Project Title: Hinckley NRF Interchange

Report Reference: 794-PLN-TRP-JNY10702-11

Date: 06 February 2024

Further Review of DCO Transport Assessment

Project - Originator - Zone - Level - Type - Role - Number	Status	Rev
HRF-BWB-GEN-XX-DR-TR-111	S2	P02

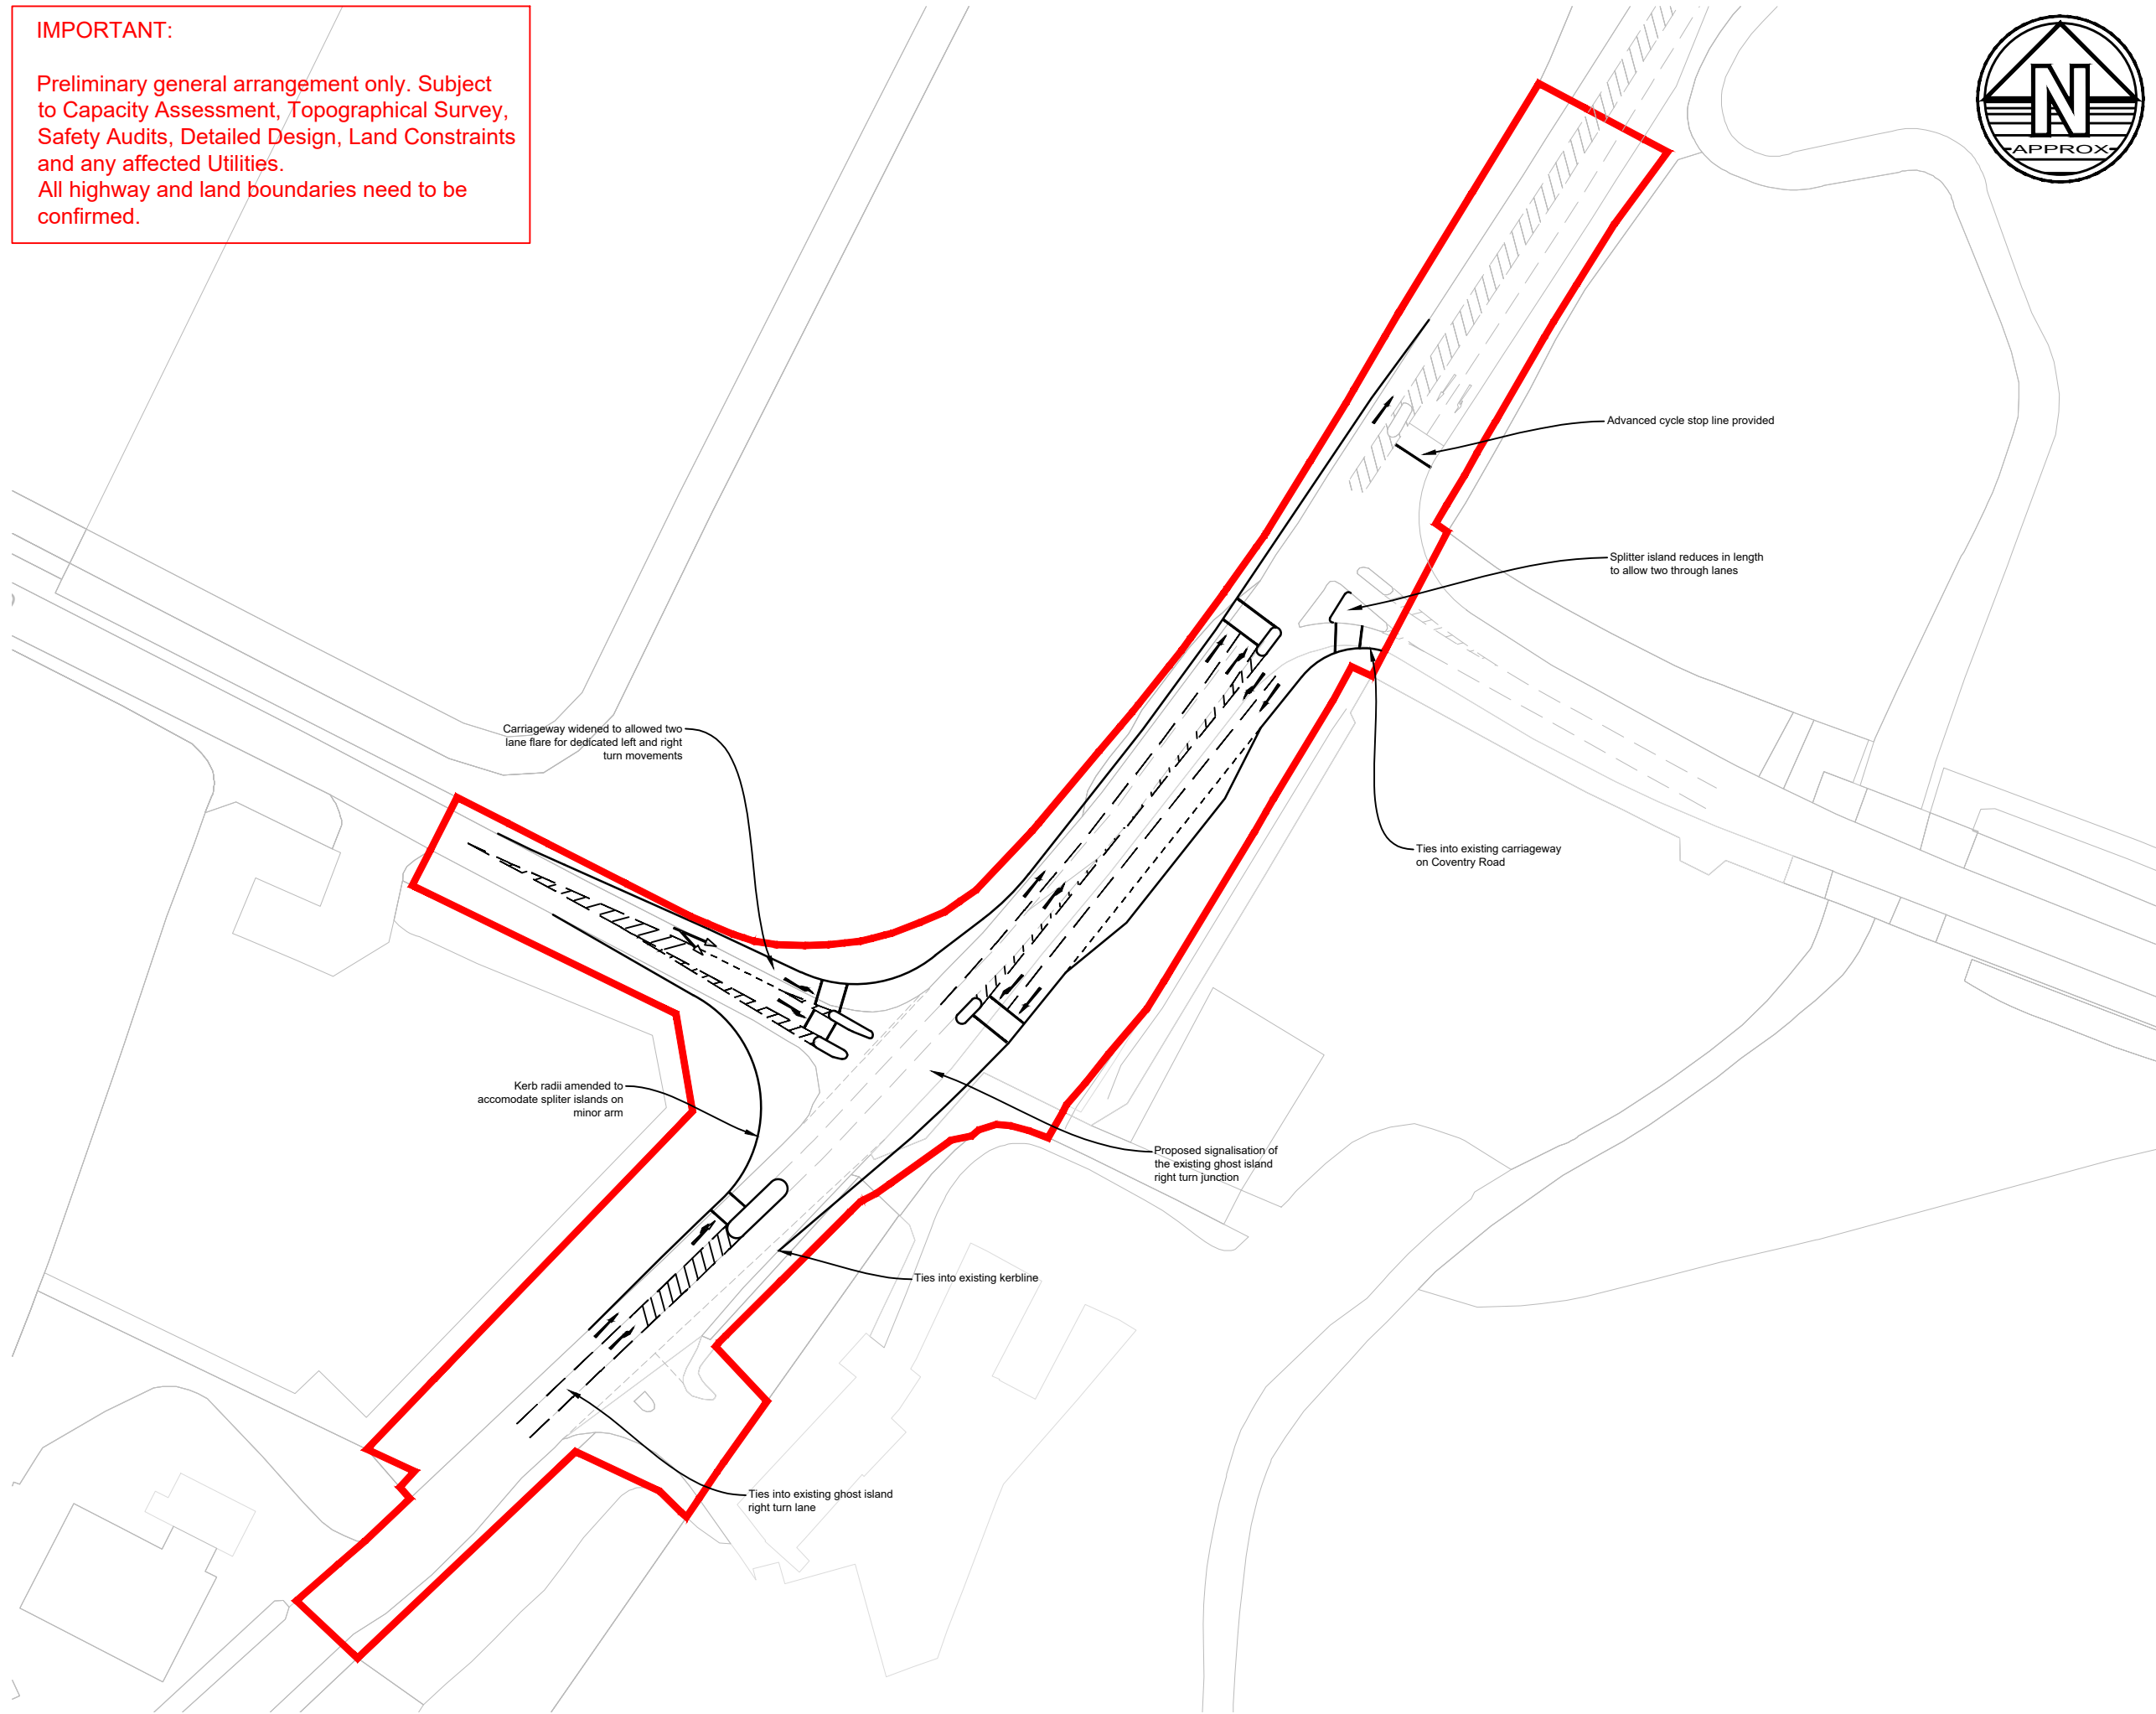
- 1.26 When reviewing the measures within Sapcote, the RSA report highlights that the documents provided to the RSA Audit team includes the RSA Brief and the proposed scheme of works for Sapcote, Drawing no. HRF-BWB-GEN-XX-DR-TR-111 Rev P3. What is not clear is whether any vehicle tracking was provided, existing accident data, existing and proposed traffic flows, pedestrian crossing movements, etc. Hence whilst an interim RSA 1 was undertaken it is not clear as to how comprehensive this was.

- 1.27 The measures proposed include for proposed traffic calming, a pedestrian crossing relocation and a bus stop relocation. All of these are fairly minor works to address the impact of the development traffic passing through Sapcote.

- 1.28 The recommendations of the audit team highlight the issues surrounding the proposals which include concerns over the forward visibility at the bus stop, pedestrian visibility at the new crossing, and the width of the footway at the proposed crossing location. All of these points reflect the constrained nature of the road passing through the centre of Sapcote which is not suited to increased traffic movements especially those associated with HGV traffic.

- 1.29 The Designer's Response to the RSA is to agree with the points raised, albeit to make minor amendments in an effort to address the RSA concerns regarding the bus stop and pedestrian crossing. However, the proposed traffic calming / gateway features have been removed from the scheme. Hence the resultant measures within Sapcote seek to relocate the pedestrian crossing and bus stop in an effort to better accommodate large HGV vehicles passing through the settlement. RPS consider that such measures do not address the impact of the development.

- 1.40 In relation to the Road Safety Audits undertaken, it is clear that the measure proposed for Sapcote are not acceptable in terms of road safety. Whilst some alterations are proposed by BWB these works offer limited benefit to Sapcote when set against the increase in traffic passing through this settlement as a consequence of the DCO application.
